re: Concept Plan and Project Application for CSR Erskine Park Eastern Lands:-Response to Issues Raised in Submissions

Reference is made to your letter dated 25 October 2006 providing the proponent, CSR Limited, with copies of all submissions received during the public exhibition of the proposed storage and distribution centre at Lenore Lane Erskine Park. In accordance with Section 75H(6) of the EP&A Act we write on behalf of CSR Limited to respond to the issues raised in the submissions. We also respond to the submission from Penrith City Council.

Drawing:
TYPICAL STORMWATER CONTROL
BASIN PAD 4

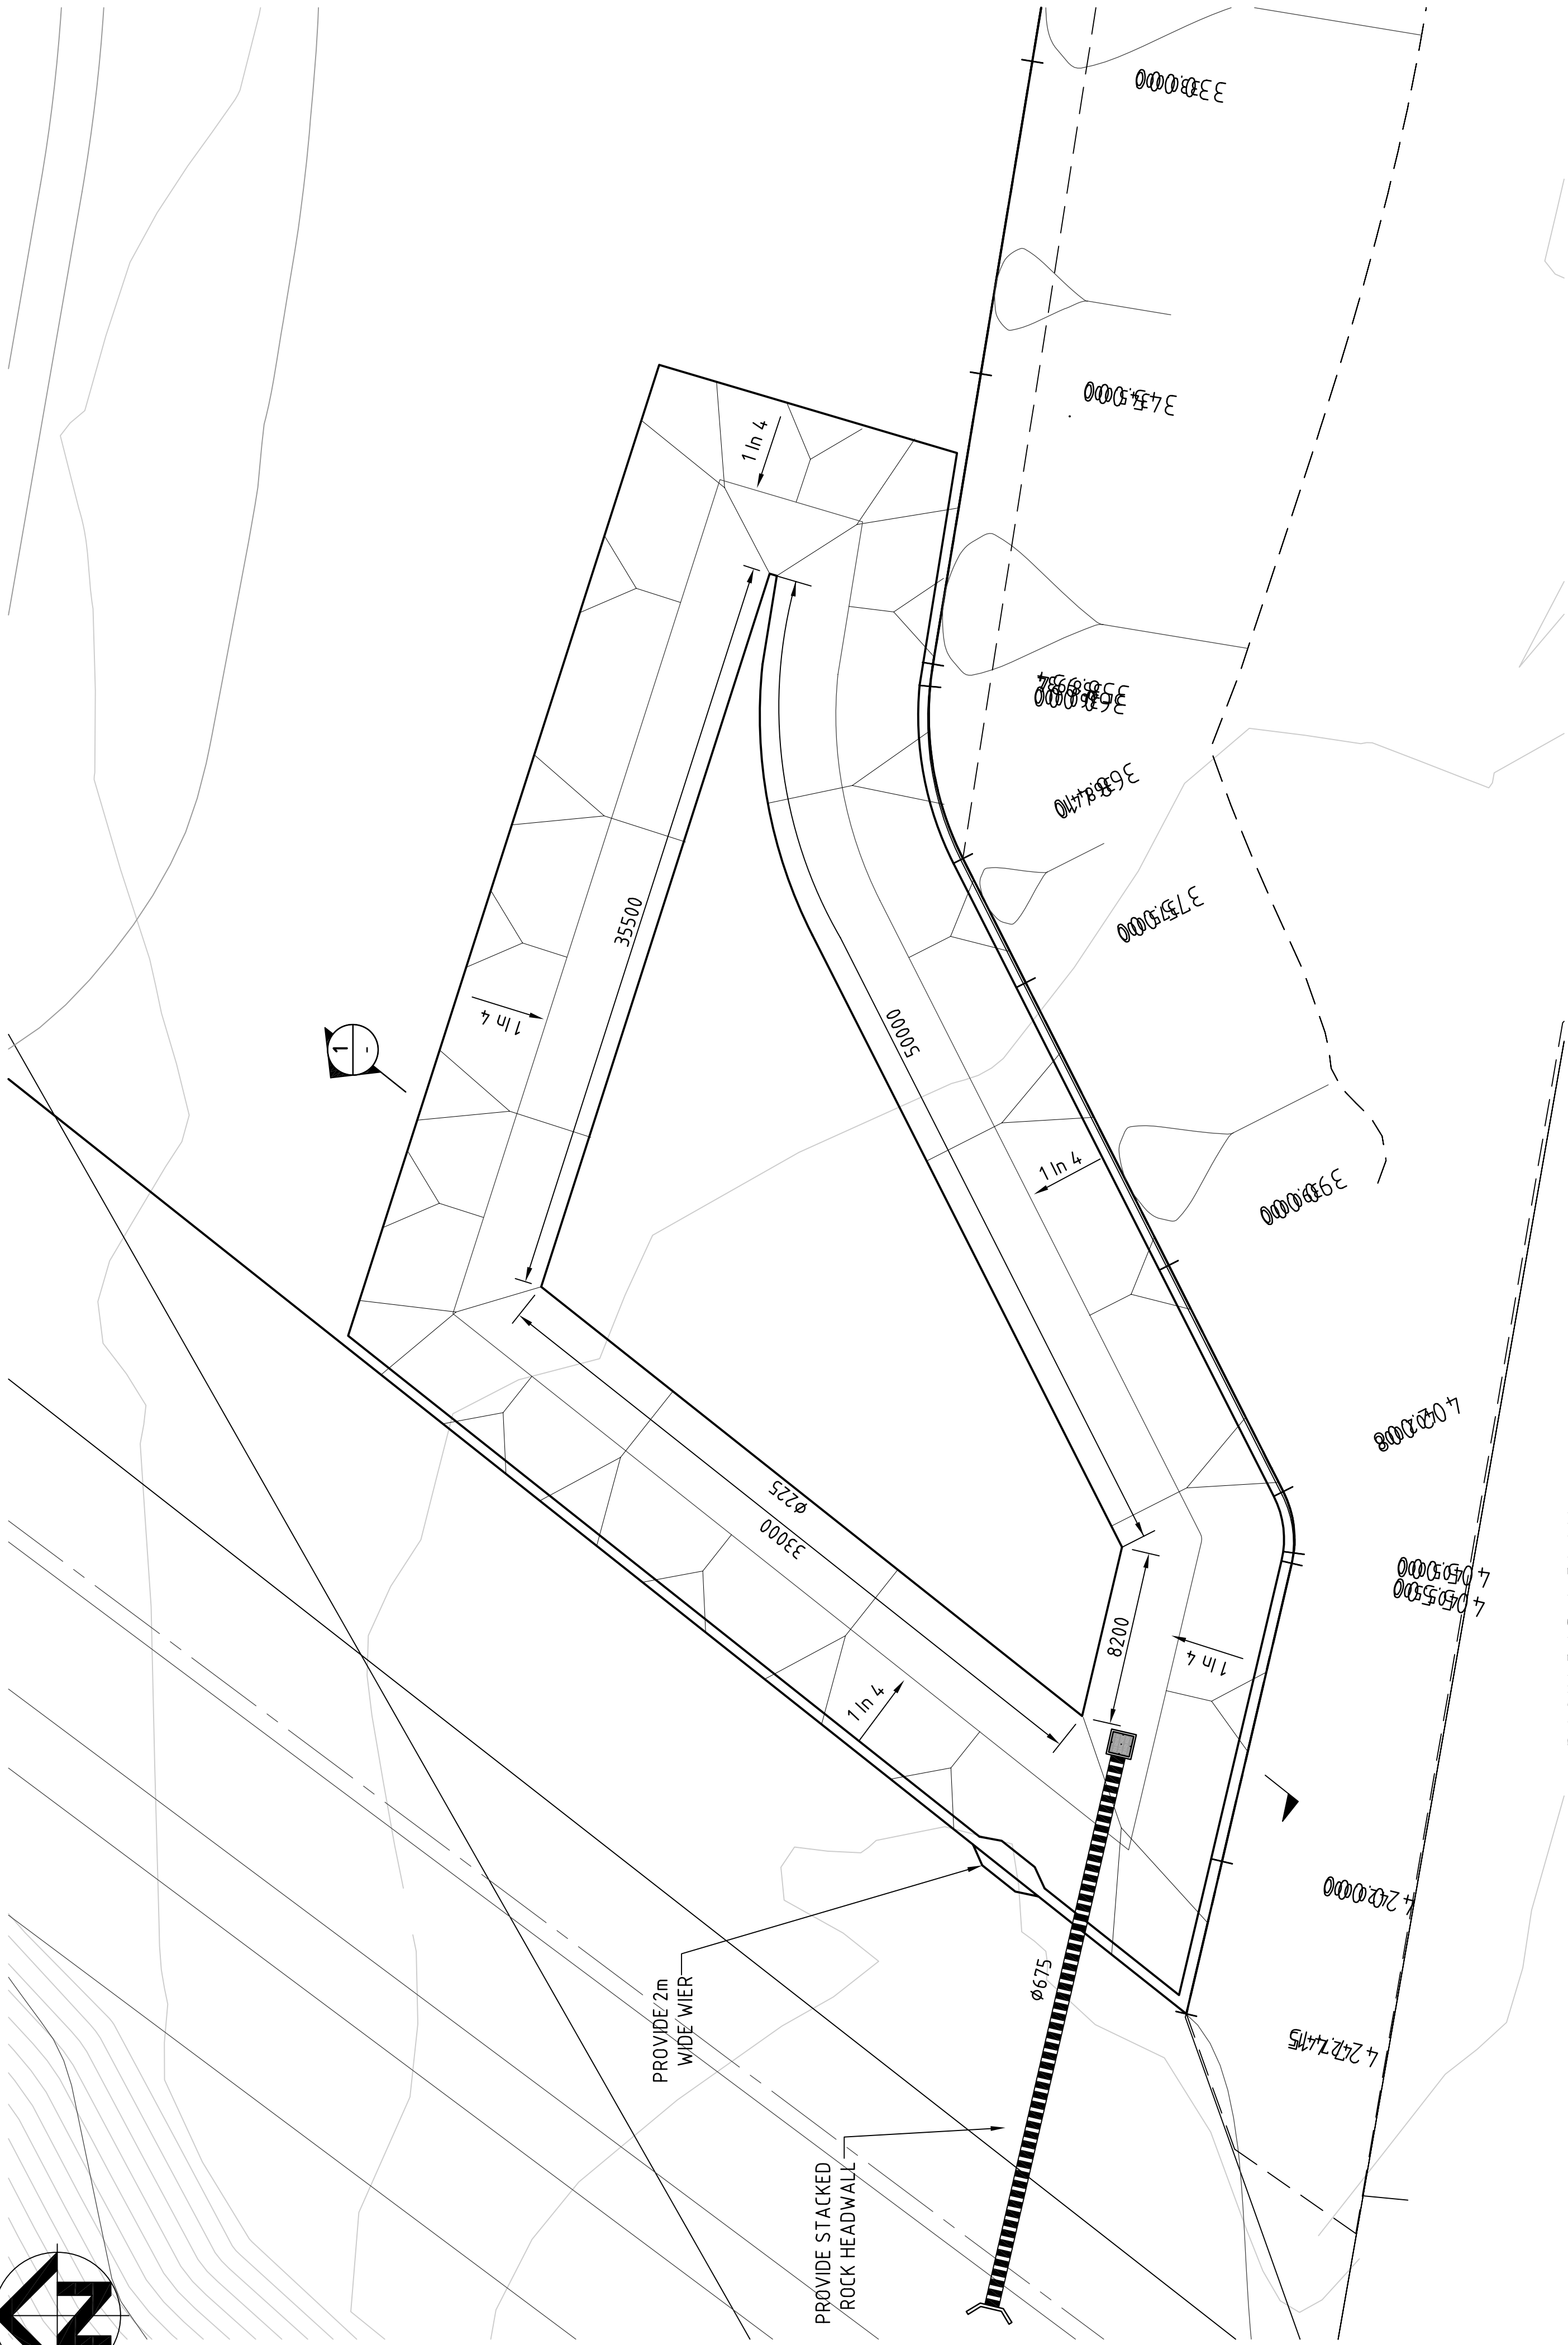
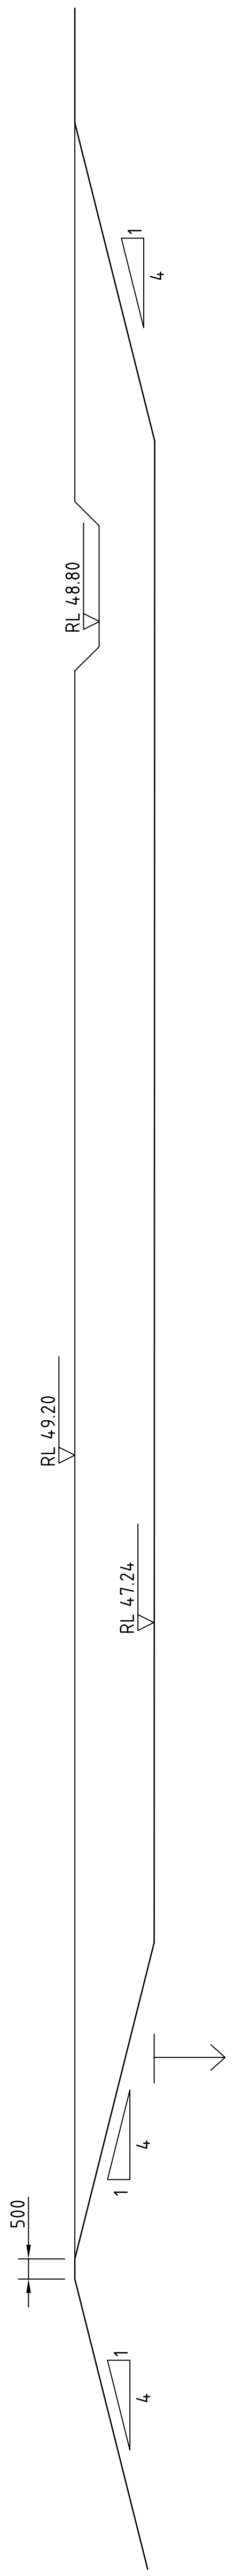
Whilst detention basins are proposed to reduce post-development flows, they are inadequate in size and complexity to control the full range of post development flood peaks, in particular the basin adjoining the Jacfin land. It appears that from the very limited information available in the EAR reports that only a preliminary assessment has been undertaken of the detention basin requirements.

The sizing and location of the basins has been provided as a guide and framework for the future development of the site. They have been provided to determine the storage and discharge requirements for each of the pads, for a range of storm events. Except for Pad 4 the ultimate use of each of the pads is unknown at this time and the application is for the

formation of these pads. The design of these basins is for the detention of water from the pads in their current form. The future development of the buildings on the site will require additional stormwater detention at that stage of detailed development, however the design of the basins meets the requirements of the Development Control Plan for the area.

This approach has been previously used in other development applications within the site, with the actual configuration of the basins and other stormwater infrastructure being left to the pad specific application. A more specific stormwater concept plan has been provided for the proposed industrial development located on Pad 4.
